Application H17-0404-22
Location FAIRVIEW BIRDS DROVE SURFLEET PE11 4BE
Proposal Conversion and alterations of agricultural and nursery buildings into residential dwelling

Name Welland and Deepings Internal Drainage Board
Address Deeping House Welland Terrace Spalding PE11 2TD

Date Submitted 03-05-22
For/Against Comments

PROPOSED SITE LAYOUT PLAN - 1:250

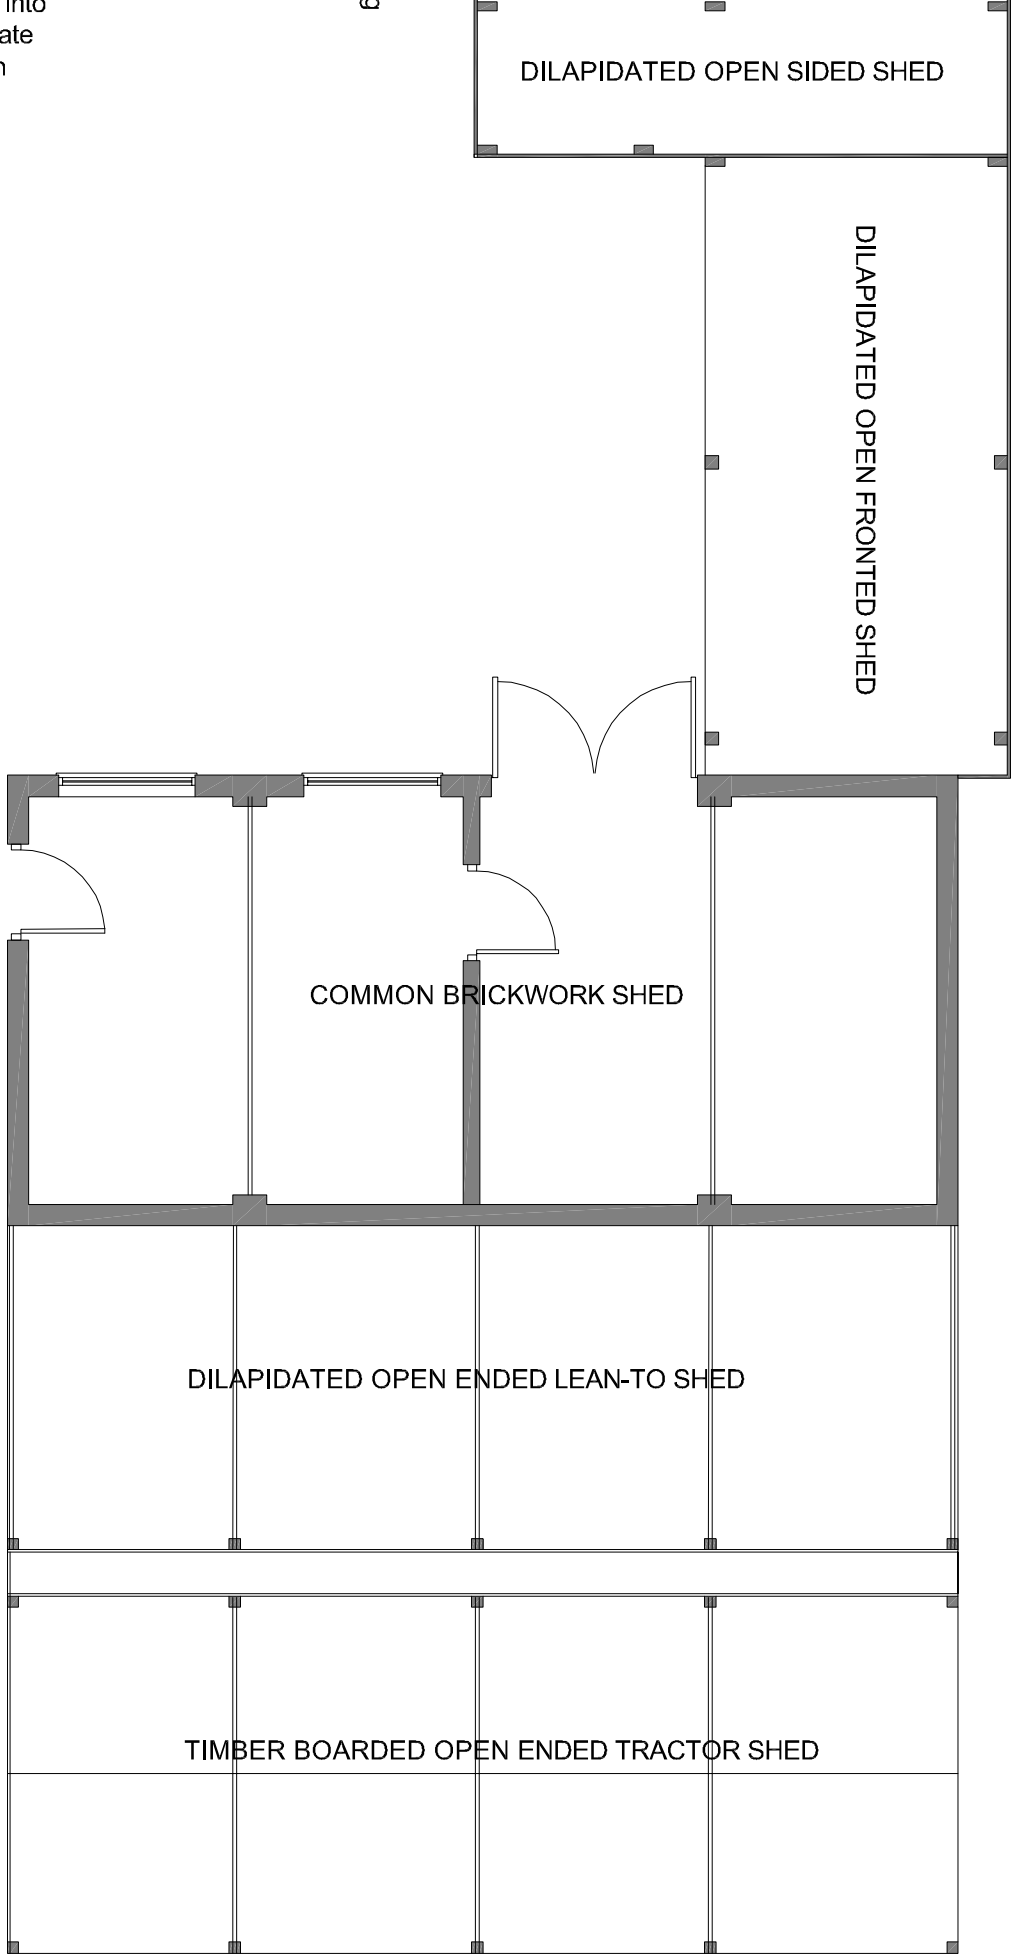
Thank you for your consultation on the above application. I note that surface water will be disposed of via soakaways and permeable surfaces. I see from the submitted plan that the access culvert serving the property is proposed to be widened. If this culvert crosses an open watercourse then the Boards prior written consent will be required and the agreement of technical details. The applicant can contact the Board directly to discuss this should planning permission be granted.
